Comment for planning application 21/01630/OUT

**APPENDIX 4
DEVELOPMENT PARAMETER PLAN 3**

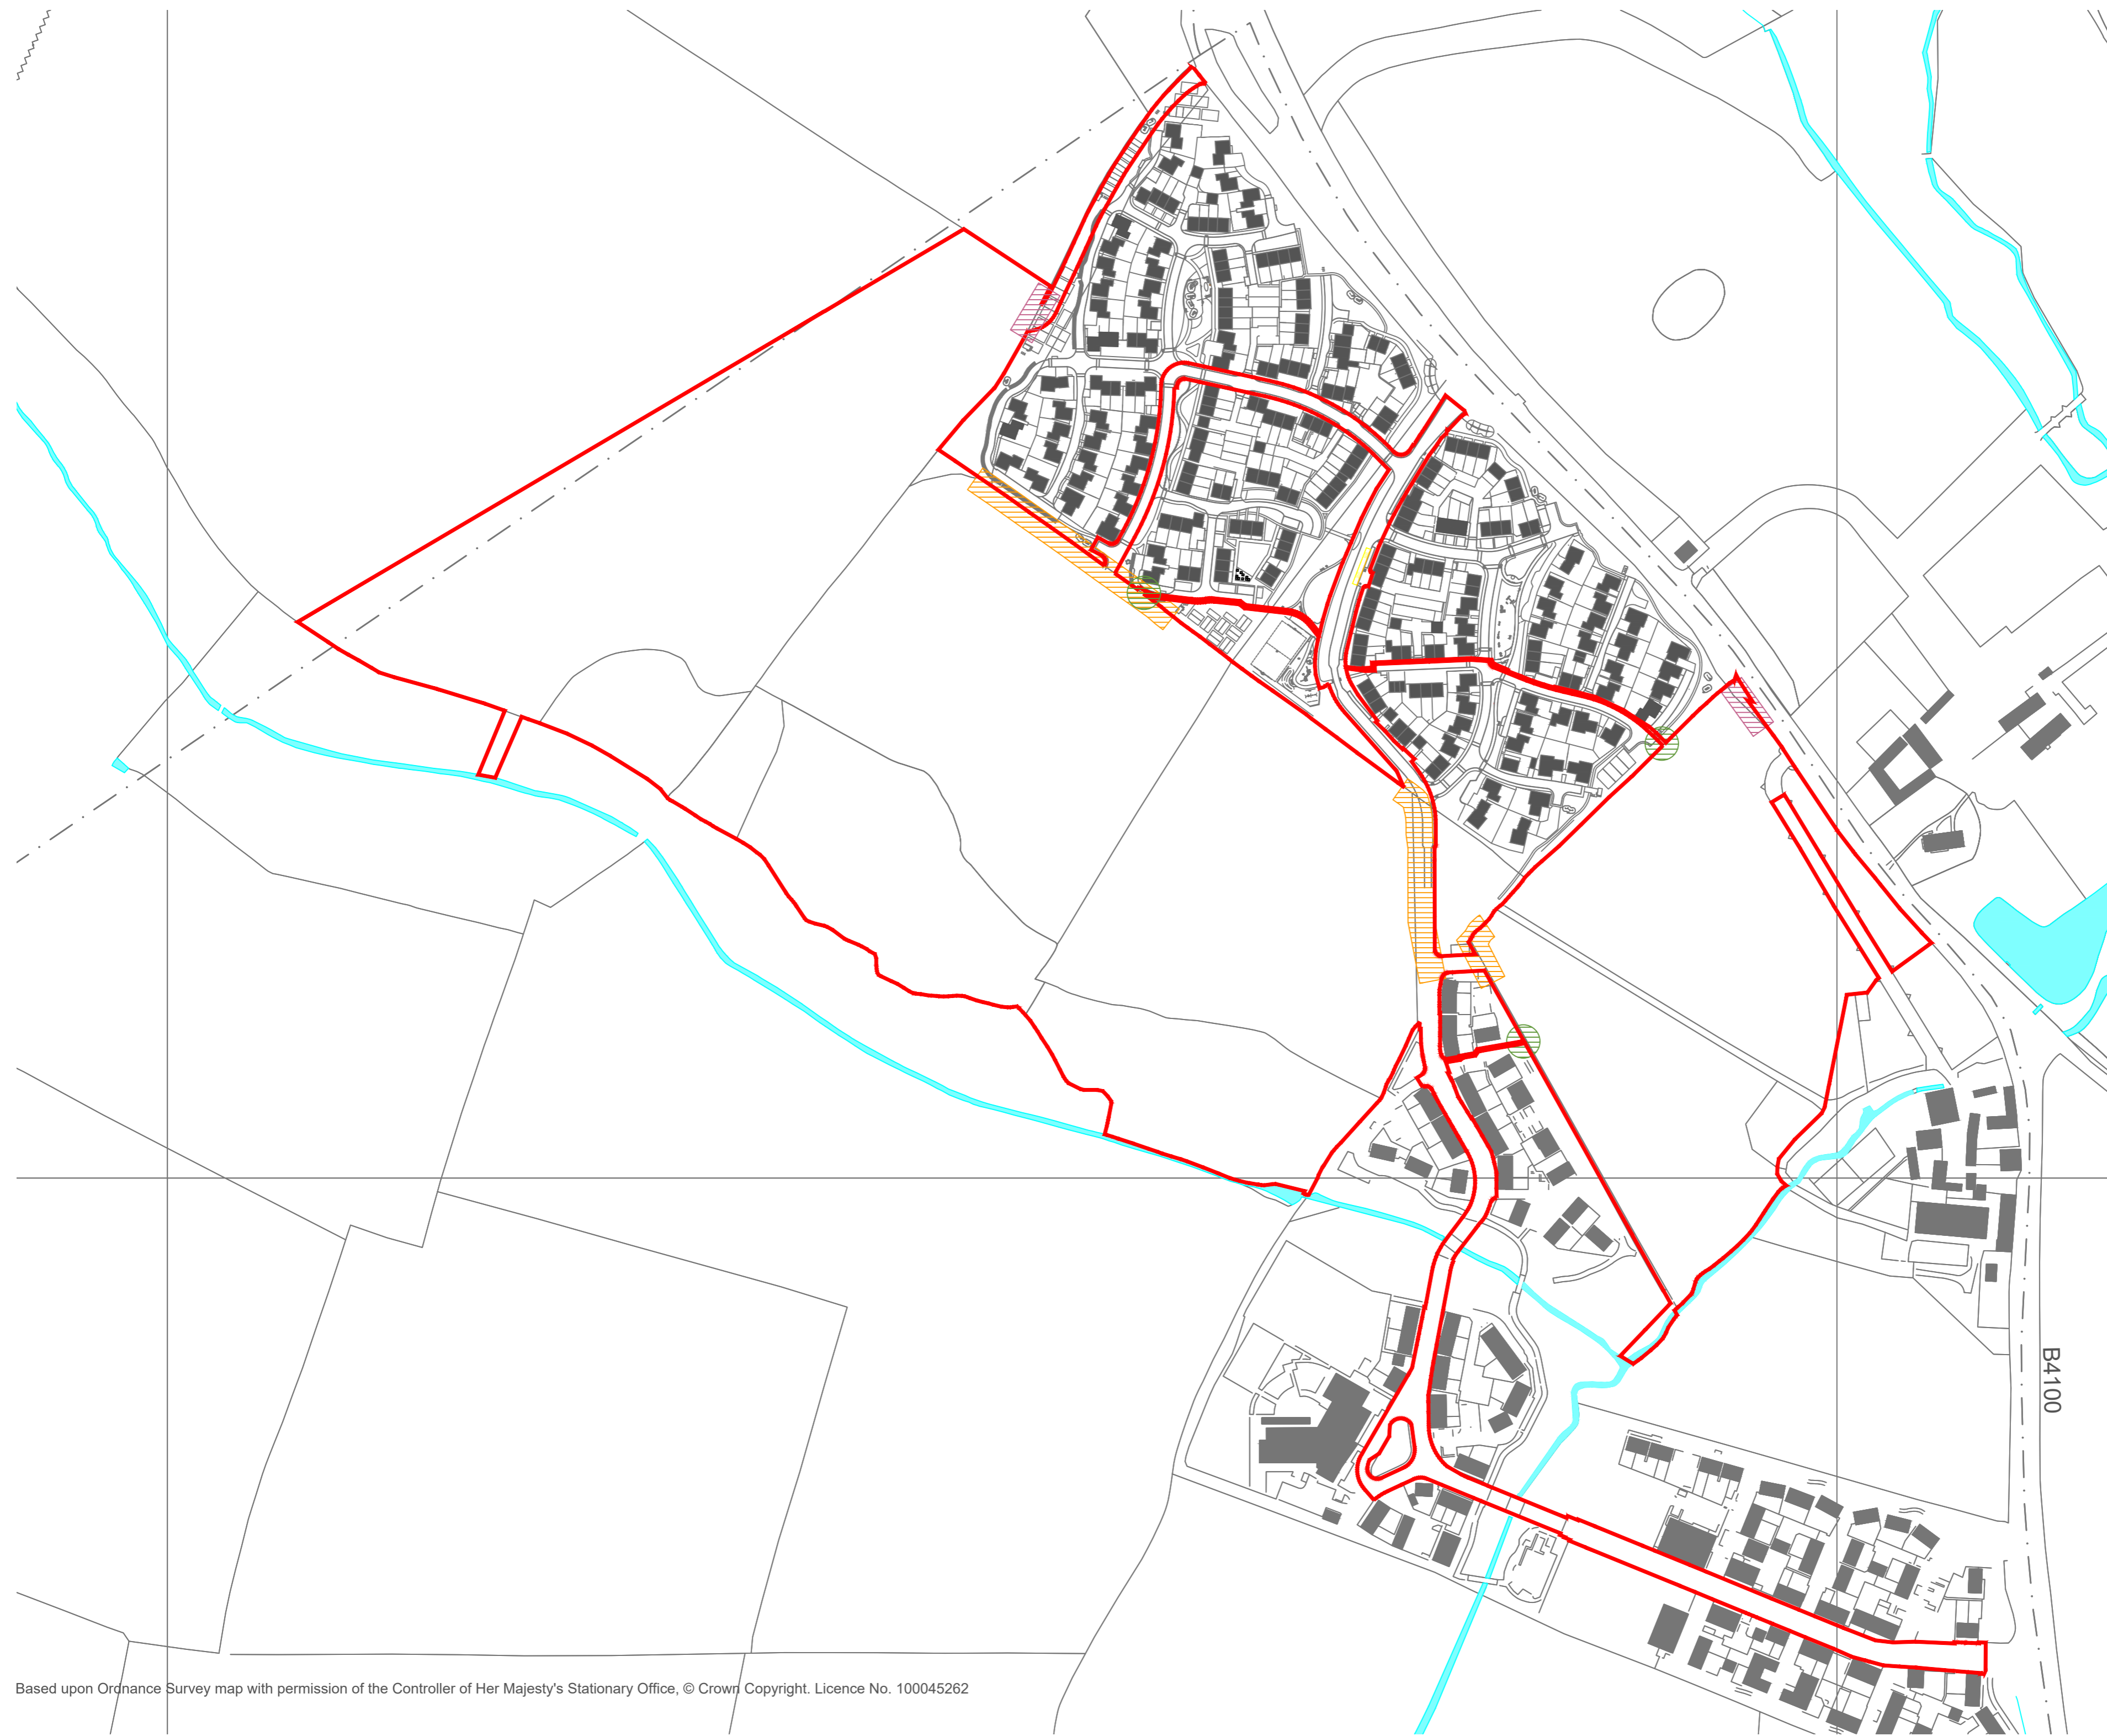
the county, including: "BIC1 - Improve access and connections between key employment and residential sites and the strategic transport system." It seems to me that the estate road layout has not been designed with best bus routing options considered: I would ask that this be reviewed, to see if it could be improved. For example: could the road through this section become a 'spine road' and link to the B4100 via a new exit at what is currently a parking area, just at the end of Phase 4? - this might resolve vehicle traffic issues, and also allow a bus route within 400 m of every home. I would also note that, as it stands, the proposed development actually makes no attempt to contribute to the transport system in NW Bicester, at all. Will the developer make a commitment to contribute towards the future running of the E1 bus service, as the developer of Elmsbrook has done? 6. The consultation documents don't appear to commit to whether or not the proposed development will be part of the existing district heating system. The district heating system was developed based on the assumption that the whole of north-west Bicester would use it and presumably the district heating system will only achieve the full benefits for the environment if it is working at full capacity. If significant parts of the development do not use the district heating system, it will mean that the whole development will not be as efficient as it could be. I would like to see a condition made that Firethorn must work with the DHS on the Exemplar Phase (and either use it as is or improve it) such that the true optimum benefits are brought to all. 7. The DAS states an objective of "Ensuring appropriate treatment of the eastern extent of the Site, providing some separation from St Laurence's Church and Home Farm and allowing for view towards the Church itself." However, the eastern area of the development will unavoidably restrict the view of the church from some houses and parts of Charlotte Avenue/Braeburn Avenue. 8. How will the building work minimise disruption to wildlife (particularly hares, deer and badgers)? Hares are quite commonly seen in the fields around Elmsbrook but were not mentioned as being among the wildlife that was identified in the survey. I think this requires further study. 9. Would it be feasible to build the footpath alongside the wood before the central area is developed? I can't see any reason why not, and this would immediately be of great benefit to local residents. 10. Furthermore, could the proposed footpaths be connected to the footpath to Bucknell early in the building process, and could the developer commit to strimmer the footpath beyond the development to make the footpath easier to walk? This would allow NW Bicester residents to walk to The Trigger Pond pub in Bucknell, for example. This would be a nice 'up front' gesture, bearing in mind the disturbances Elmsbrook residents will endure once construction commences! 11. It appears that the main road in/out of the central/western parts of the development is through what is now a hedge, which will mean that part of the hedgerow will be lost. It is also unclear whether there will be sufficient good visibility at that junction without having to lose any more of the hedgerow. Please can this be addressed, holistically along with other comments regarding the road access points?
